Notice of Exhibition of application for 50-52 Phillip Street New Hotel Stage 1 Concept DA (SSD – 10464)

Dillon Kombumerri
Chair, Heritage Council Approvals Committee
As Delegate of the Heritage Council of NSW
20 May 2021

**PROPOSED ENVELOPE - TRANSFER ZONE RL 71.63m**

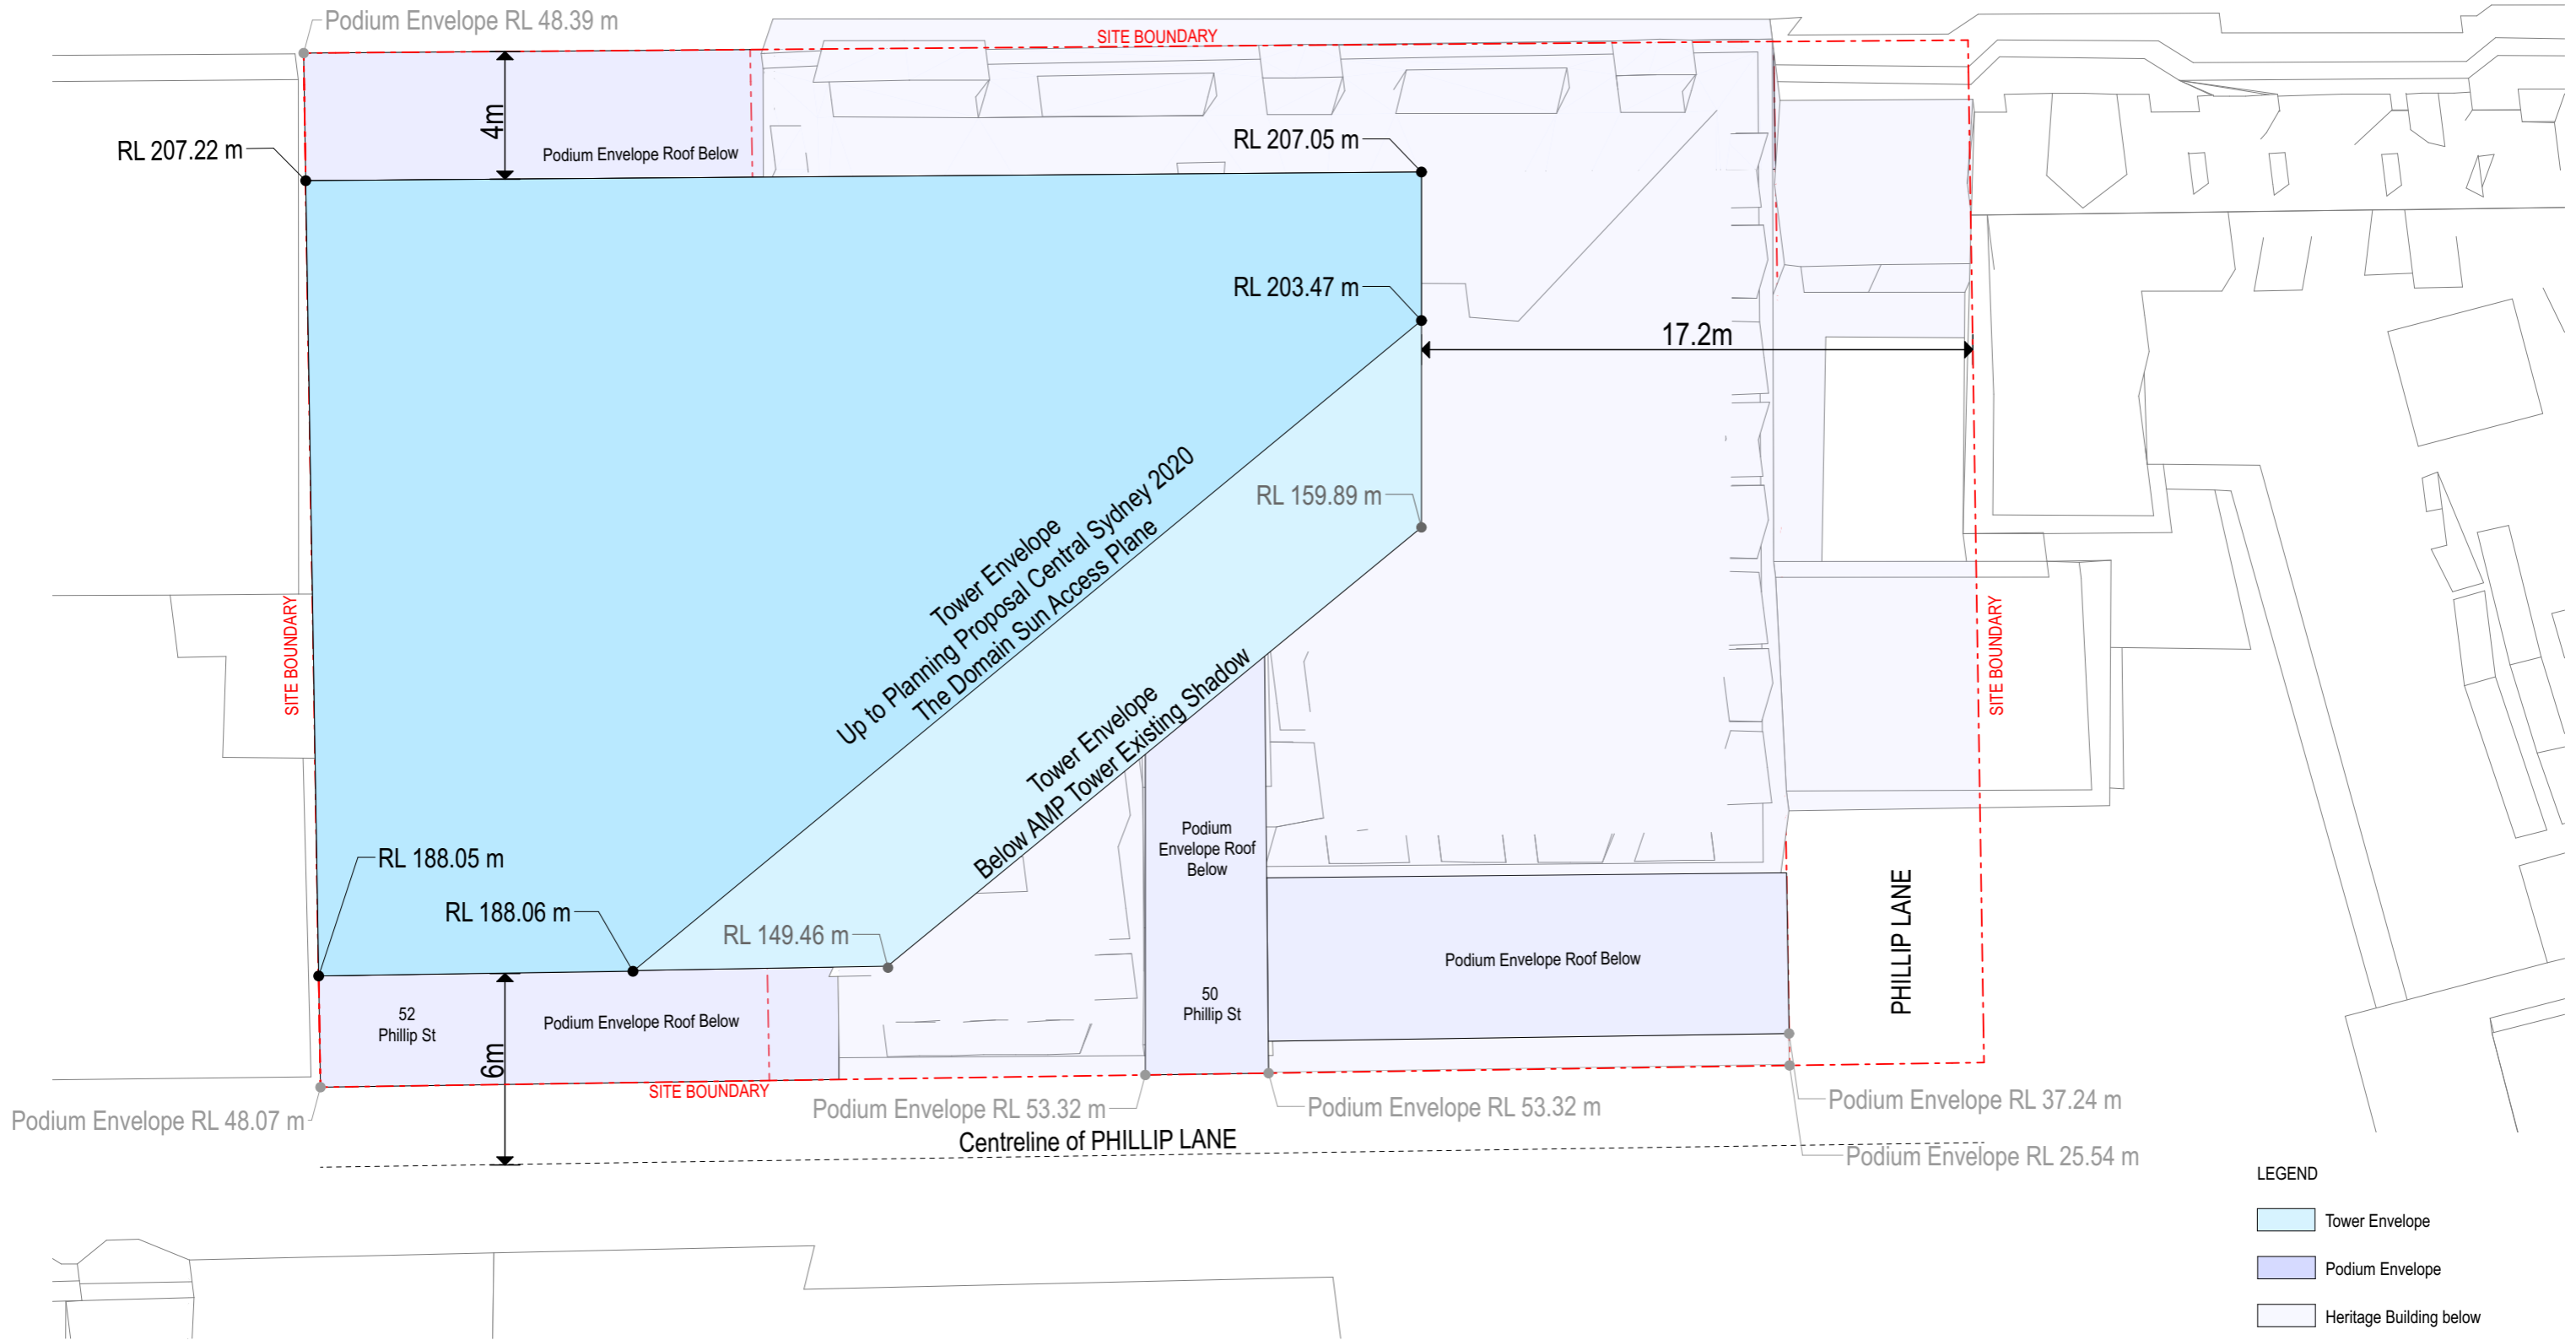
- Additionally, the proposed cantilevered portion of the tower would encroach into the air space above the former Department of Public Works Building and would permanently damage the building's relationship with the *Governors' Domain and Civic Precinct* which is listed on the National Heritage List. The development must address the potential impact on the views, setting and significance of the *Governors' Domain and Civic Precinct*.

- The increase in the setback of the proposed overhang is essential to mitigate impacts on significant views and setting of the SHR listed item within this precinct. This aspect of the proposal along with the structural column within the light well is not supported as the additions will set a detrimental precedent and materially impact the heritage values of the *Chief Secretary's Building* and other SHR items in the vicinity

NORTH-SOUTH SECTION DIAGRAM

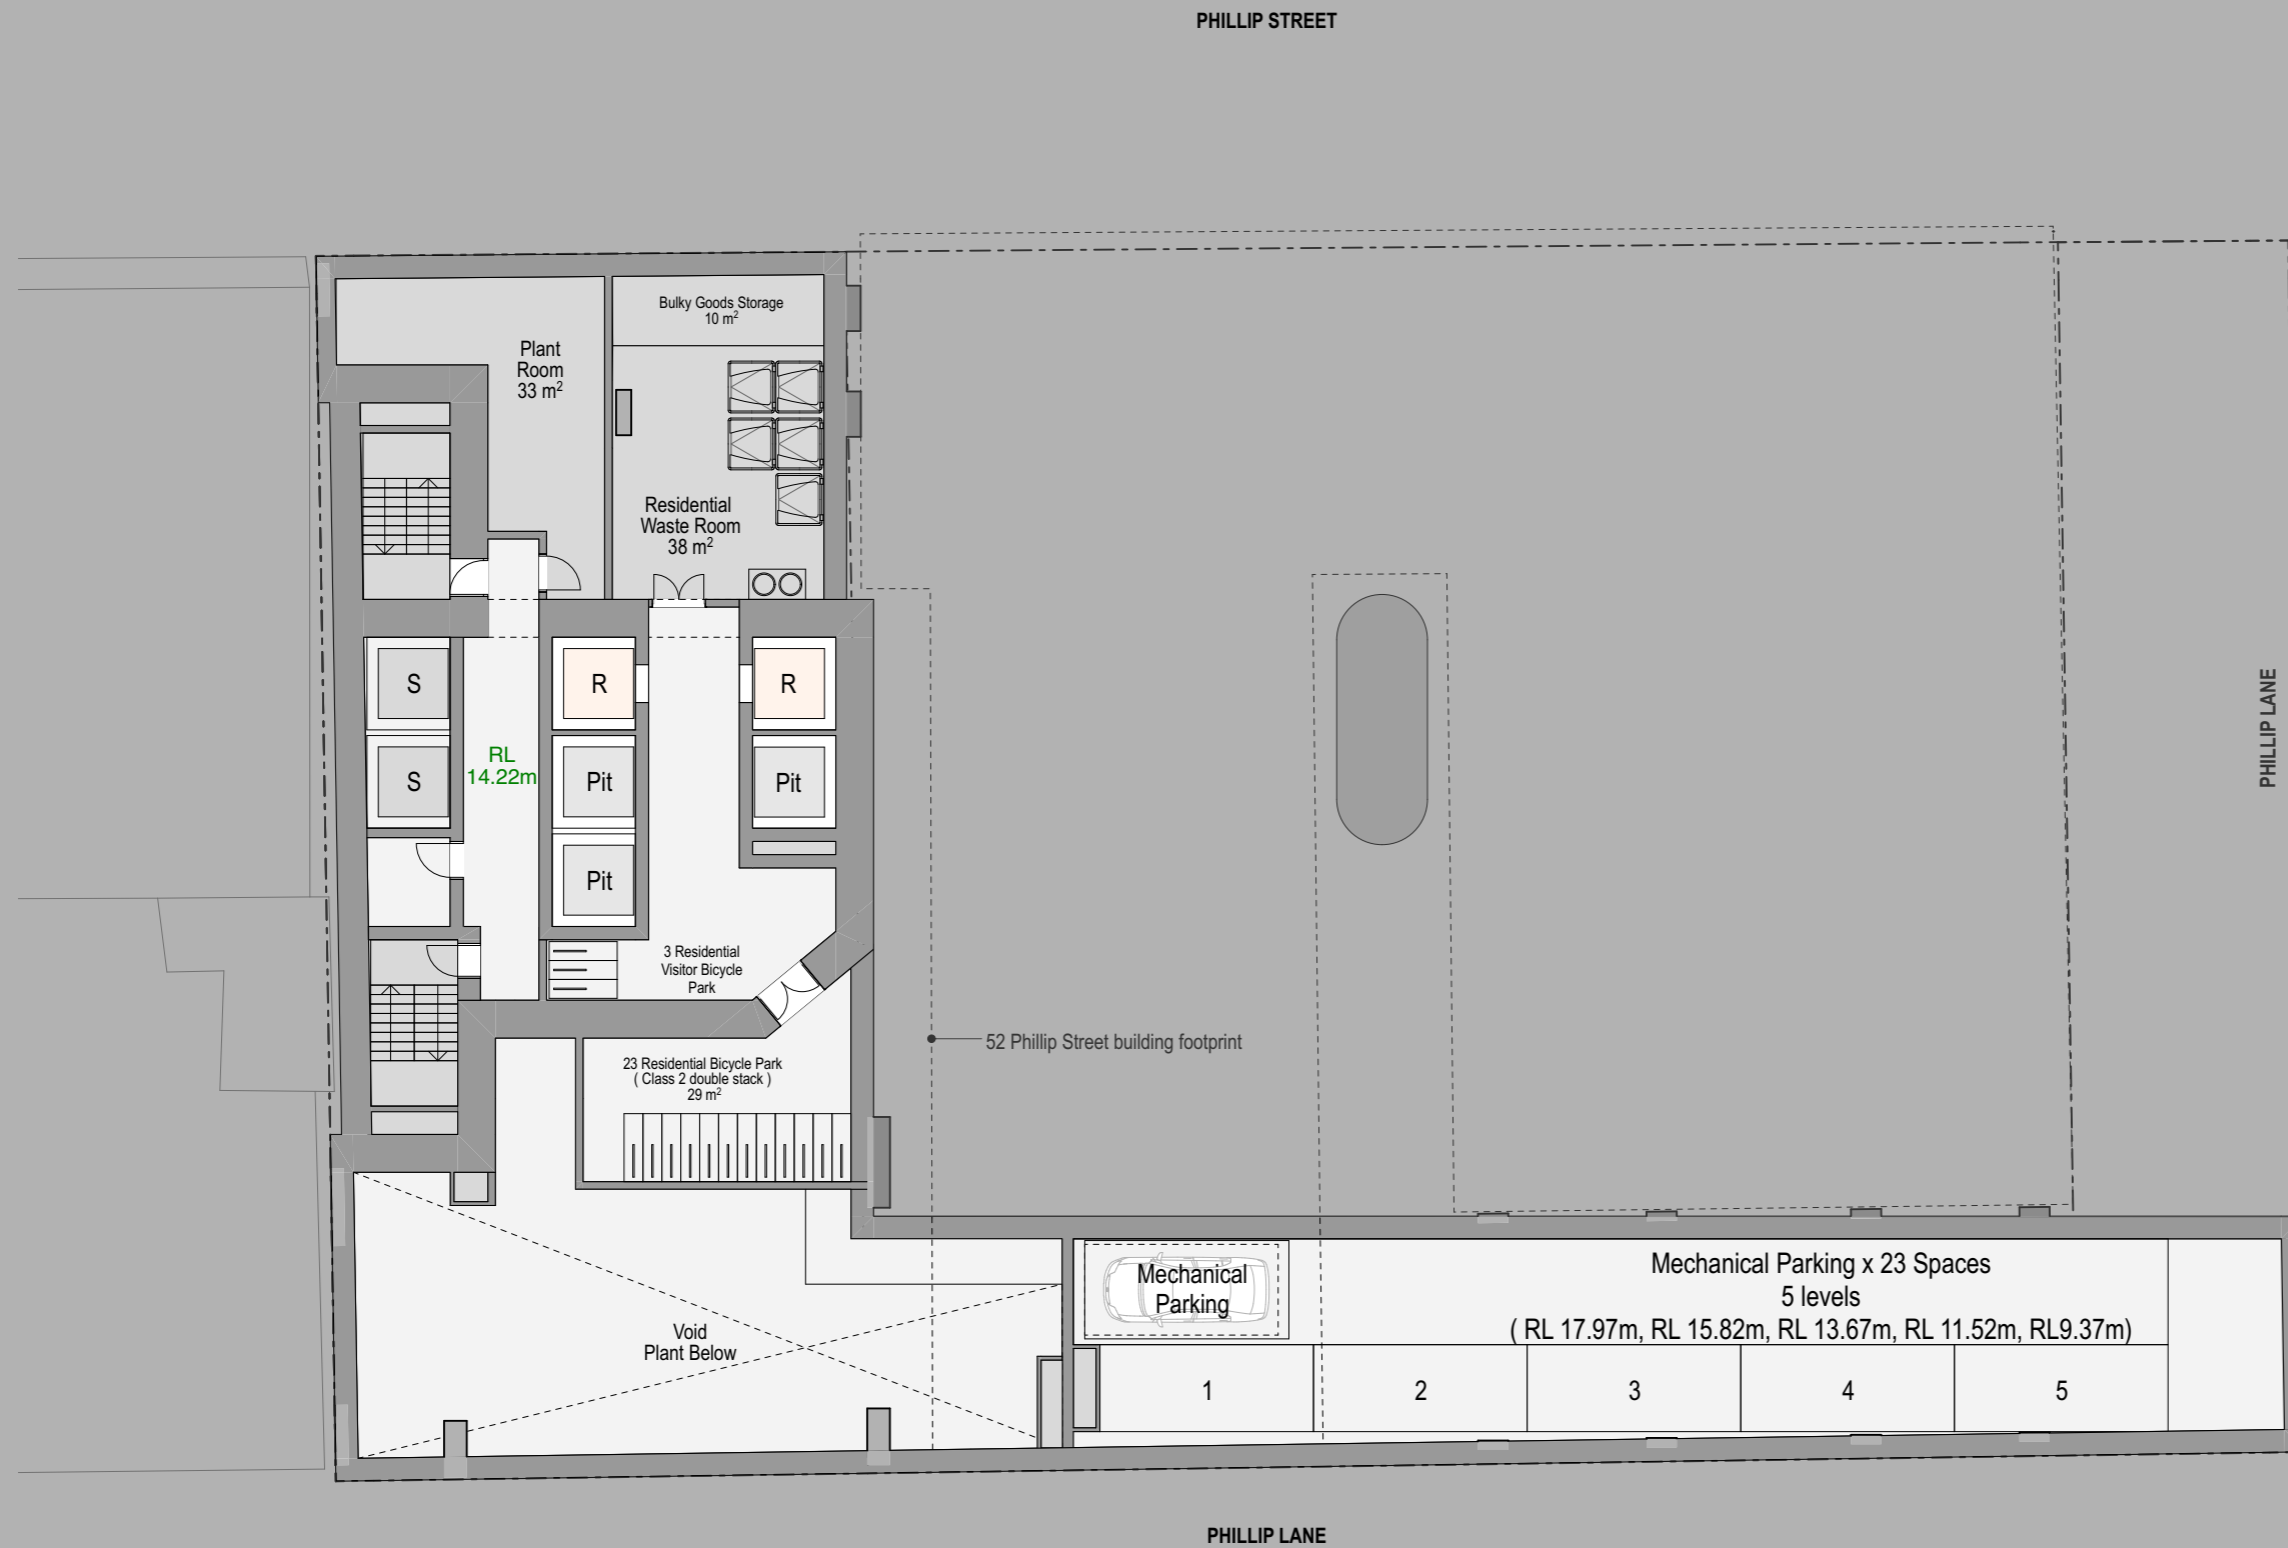
- In order to facilitate a better heritage outcome, a subcommittee of the Heritage Council Approvals Committee participated in a design workshop with the applicant on 4 December 2020 and provided further comments (Refer **Attachment 2**). The Consultation Outcomes Report Section 6.2.4 prepared by Ethos Urban provides responses to these comments. Although some have been addressed, the key issue relating to the support column intruding into the light well (of 'considerable'/'high' significance) remains outstanding.

- Alternate locations for the column and lift core should be considered as recommended by the subcommittee previously. The redesign of these elements should carefully take into consideration the overhang of the proposal above the former Department of Public Works Building as sunlight access to the lightwell is an essential attribute to maintaining its spatial quality and should be ensured by increasing the setback for the proposed development over the heritage building and by reconsidering its form.
